## EL PASO COUNTY STORMWATER MANAGEMENT PLAN CHECKLIST

G1.0

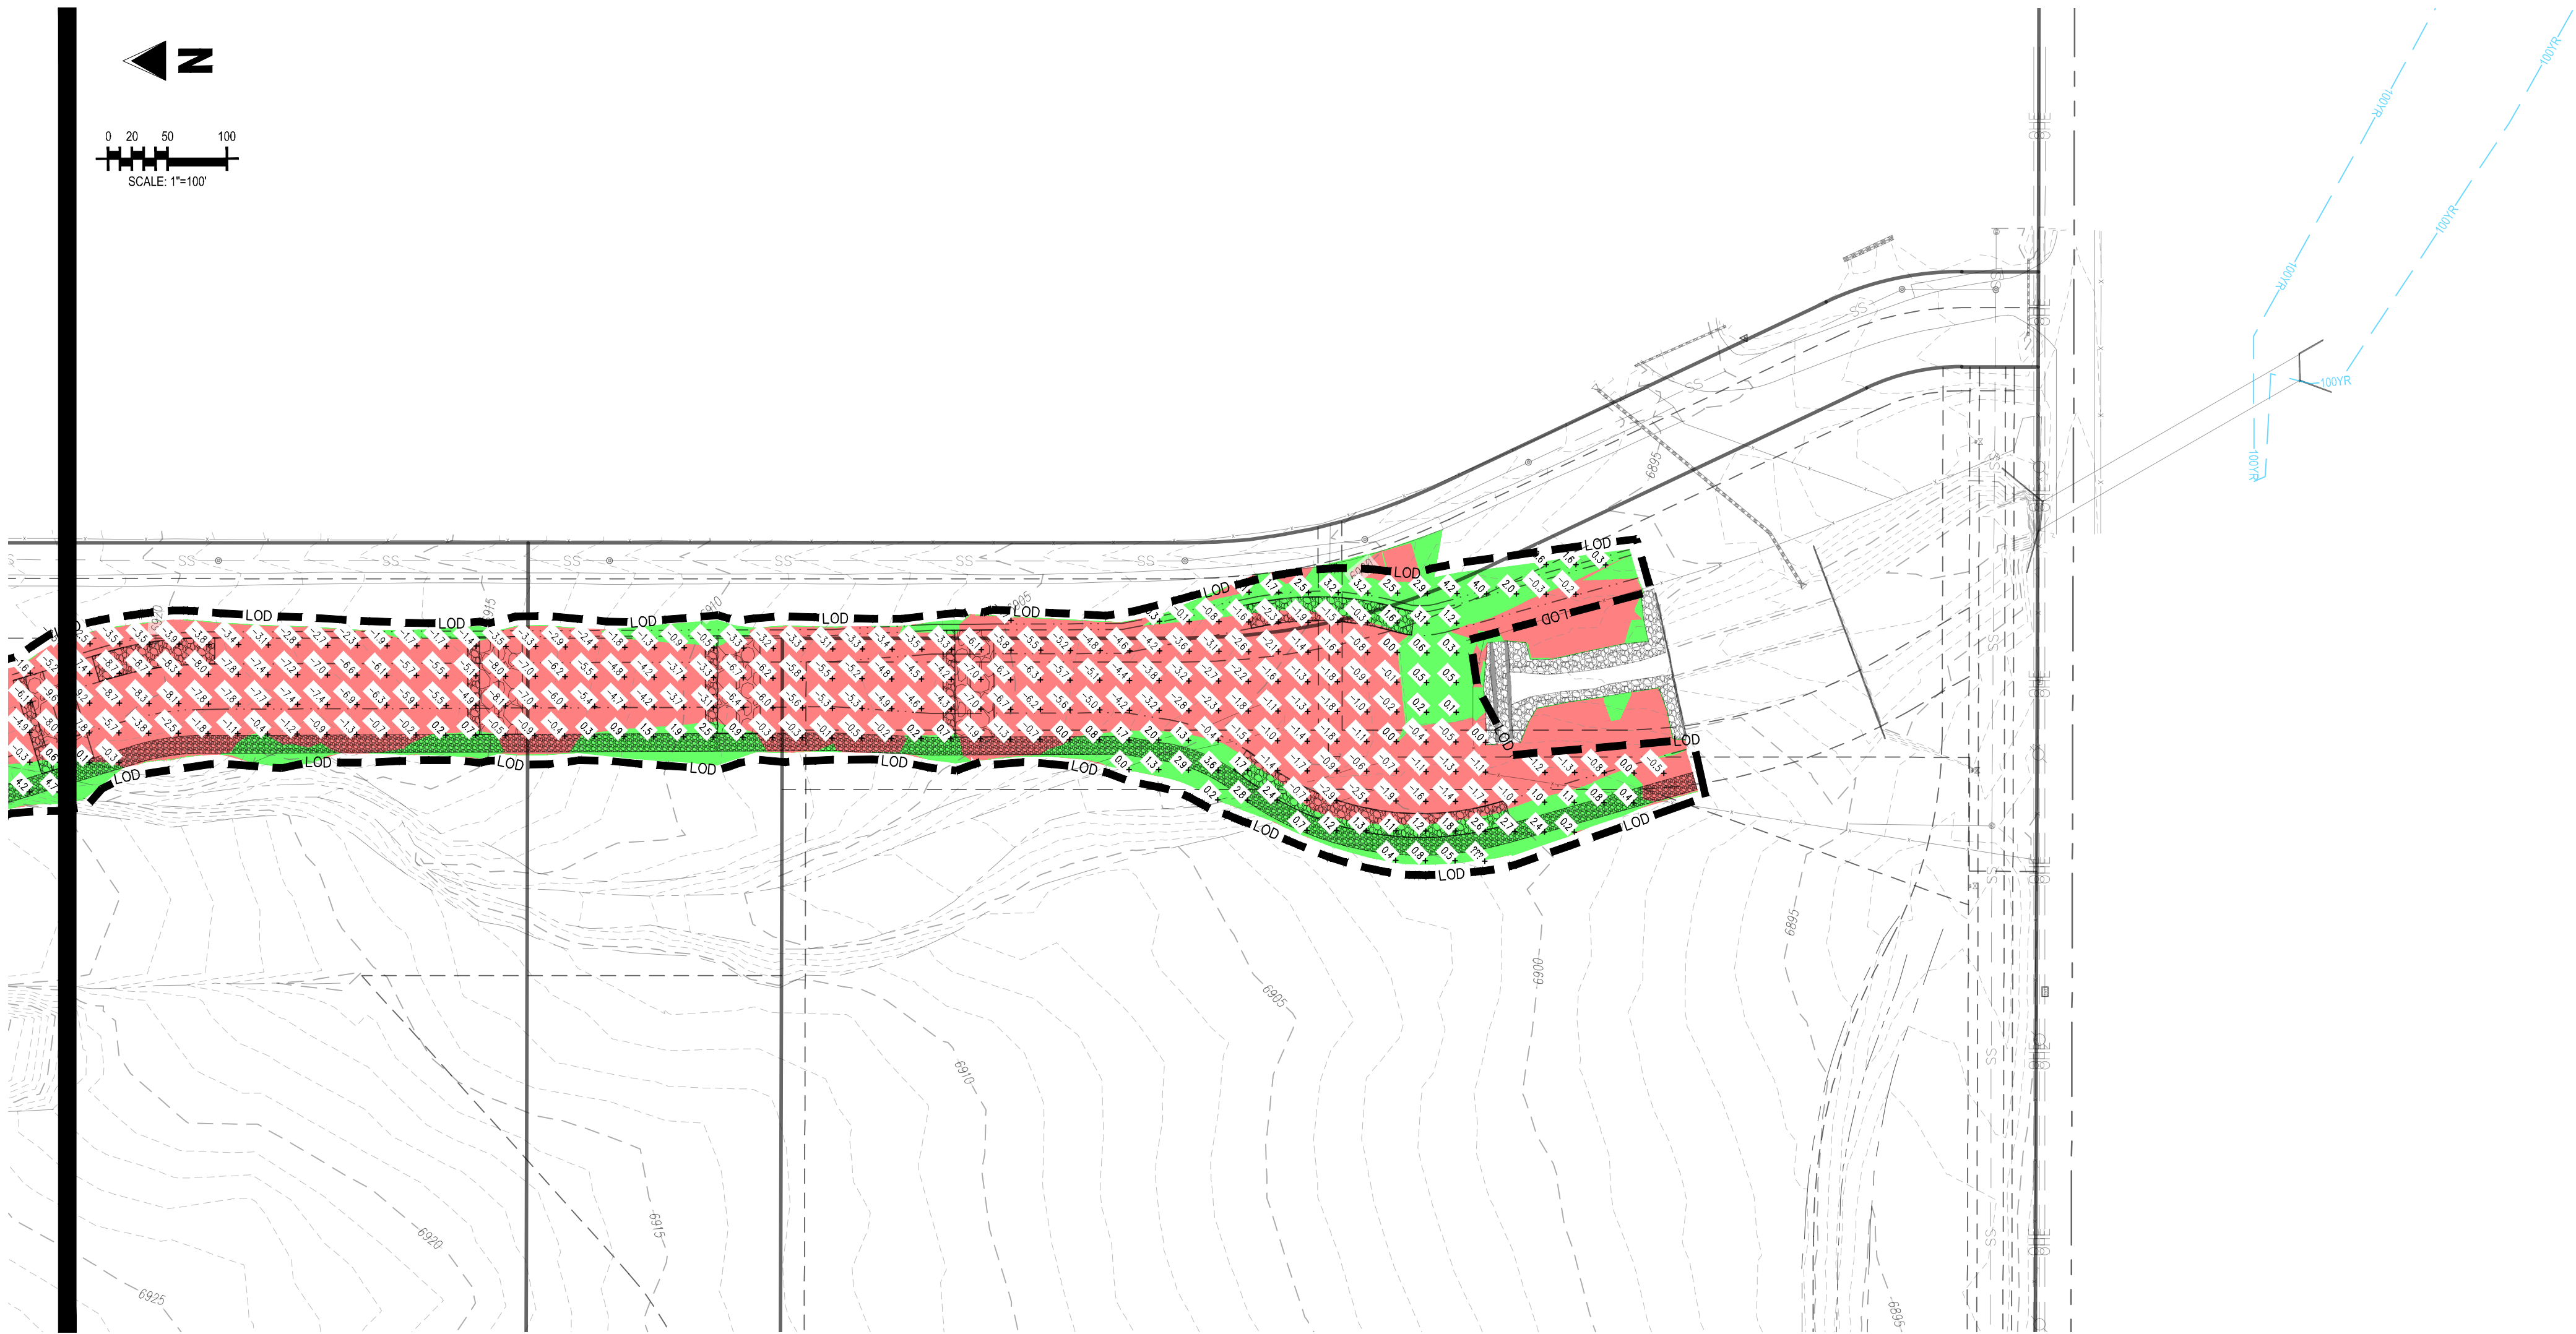
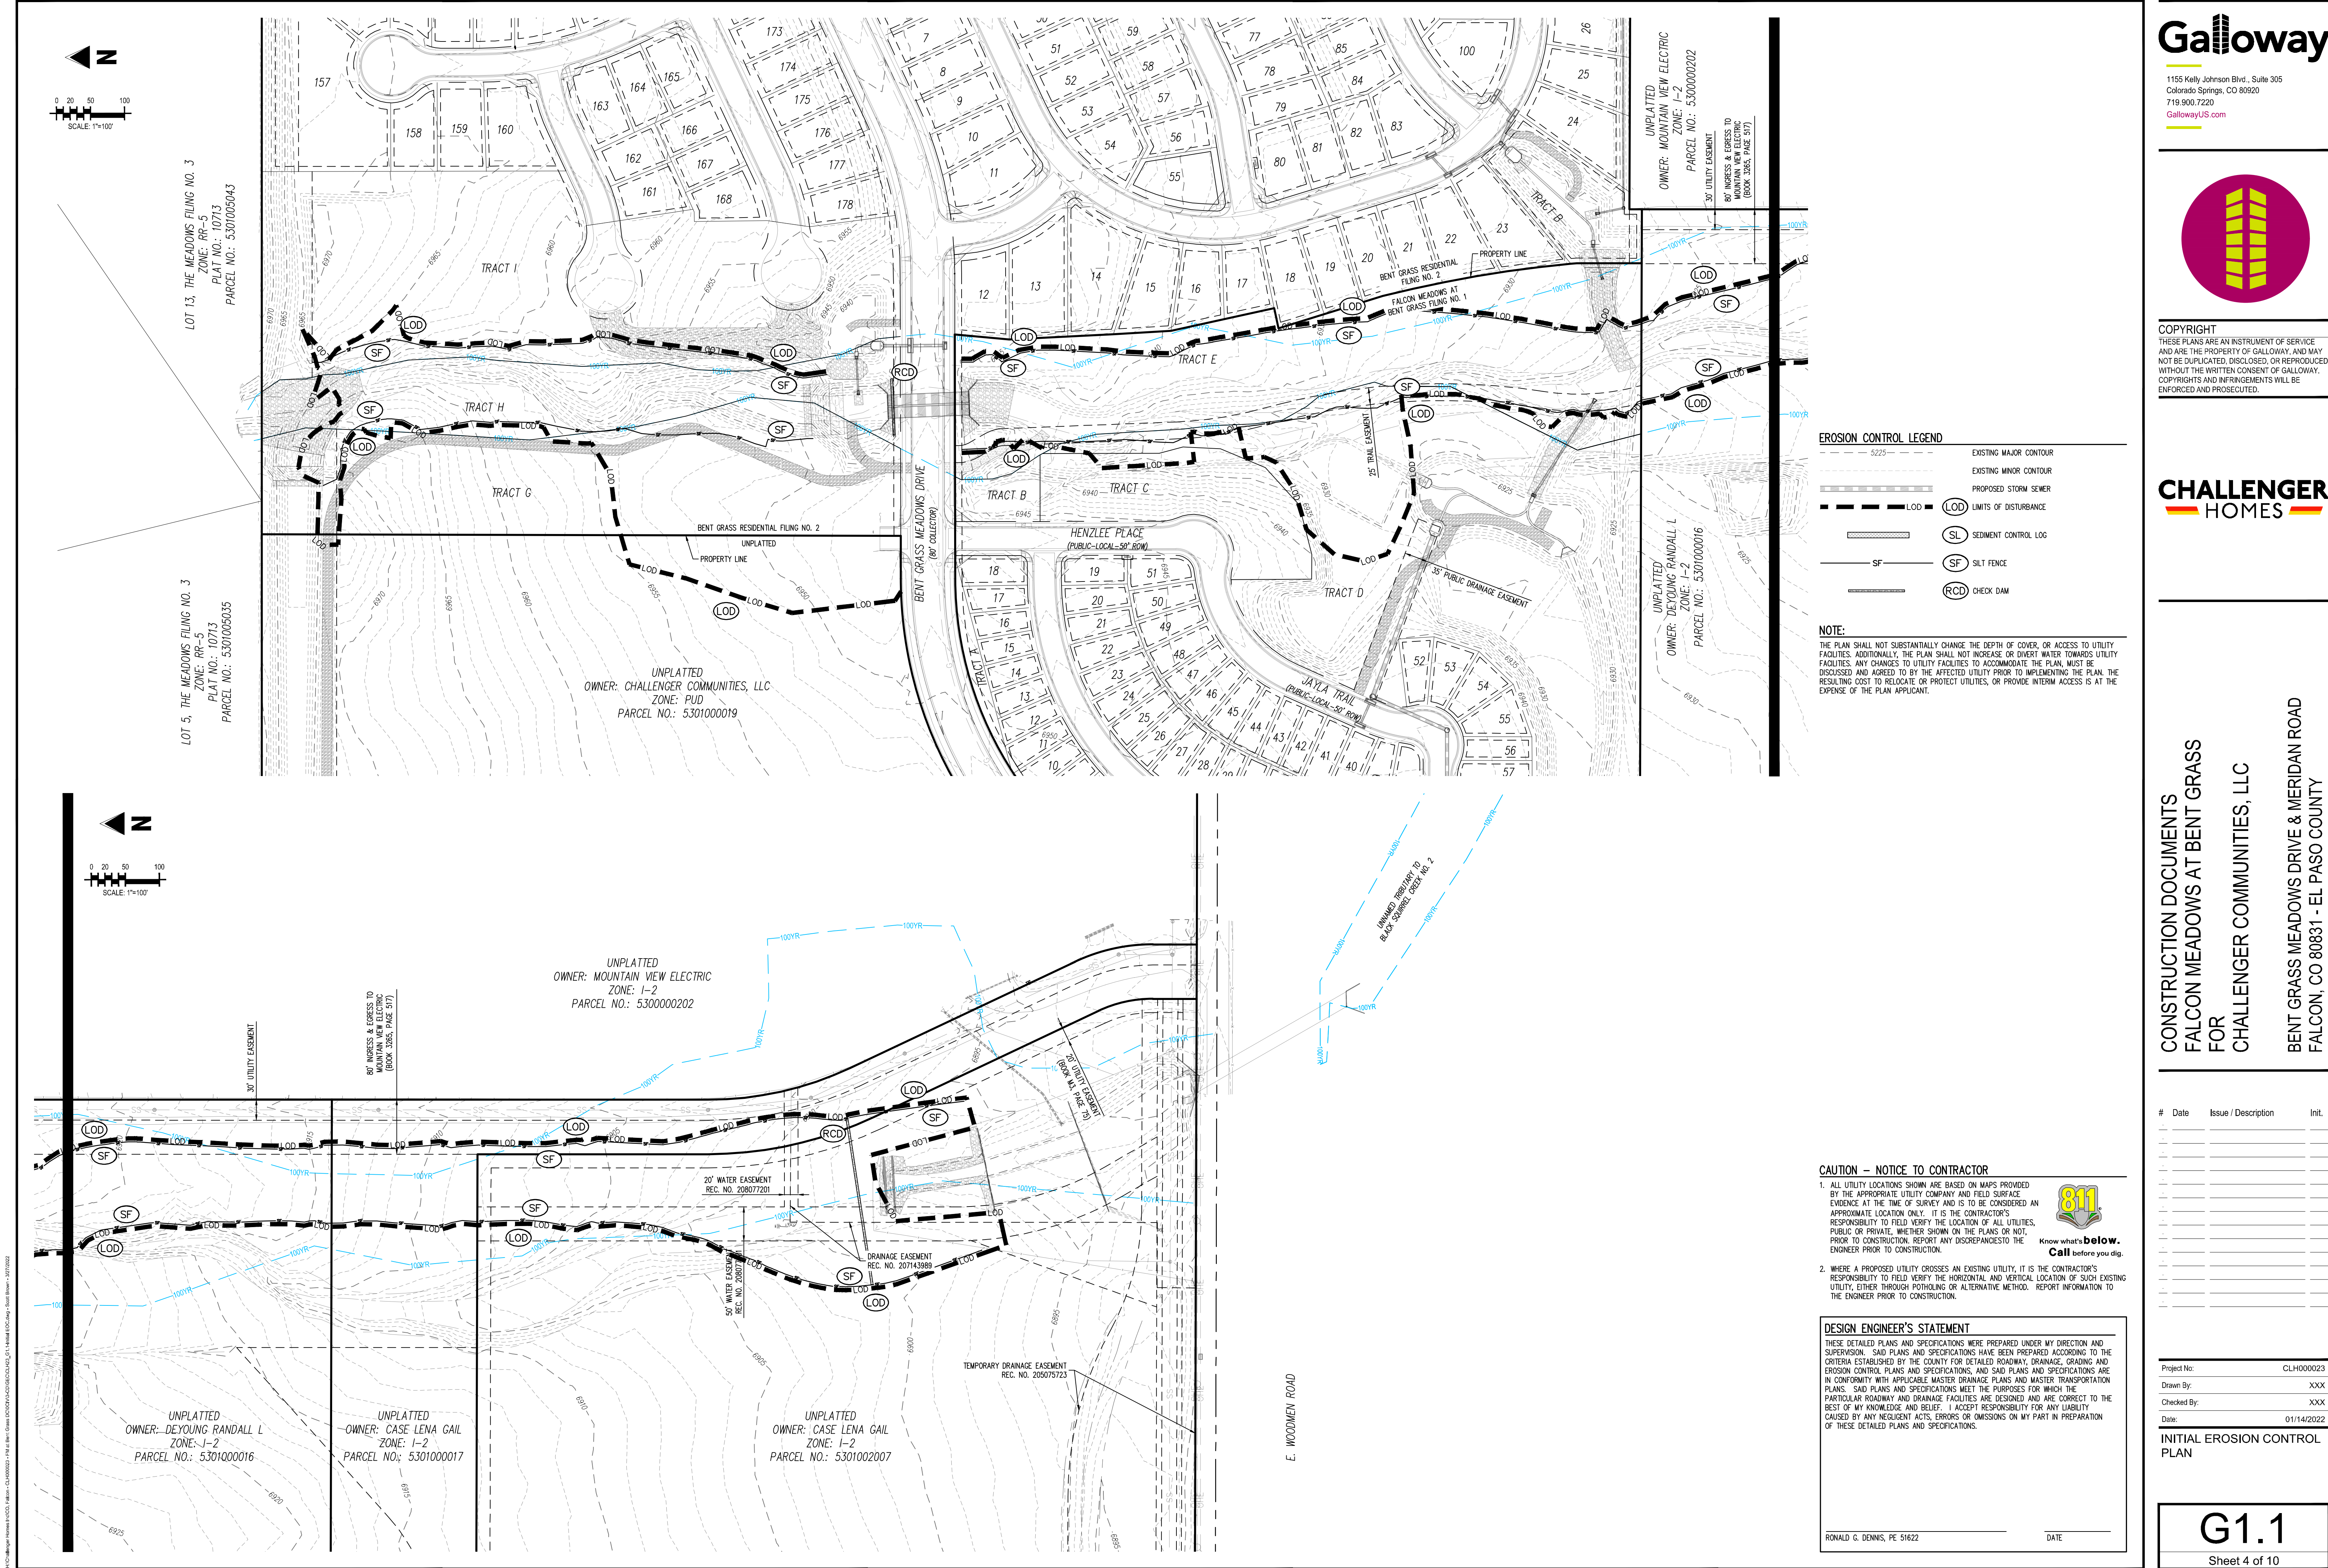
Applicant	EPC
17	SWMP Map to include:		
17a	construction site boundaries		Y
17b	flow arrows to depict stormwater flow directions		Y
17c	all areas of disturbance		Y
17d	areas of cut and fill	see comment on sht G1.0	?
17e	areas used for storage of building materials, soils (stockpiles) or wastes		Y
17f	location of any dedicated asphalt / concrete batch plants		Y
17g	location of all structural control measures		Y
17h	location of all non-structural control measures		Y
17i	springs, streams, wetlands and other surface waters, including areas that require maintenance of pre-existing vegetation within 50 feet of a receiving water		Y
18	Narrative description of all structural control measures to be used. Modifications to EPC standard control measures must meet or exceed County-approved details		Y
19	Description of all non-structural control measures to be used including seeding, mulching, protection of existing vegetation, site watering, sod placement, etc.		Y
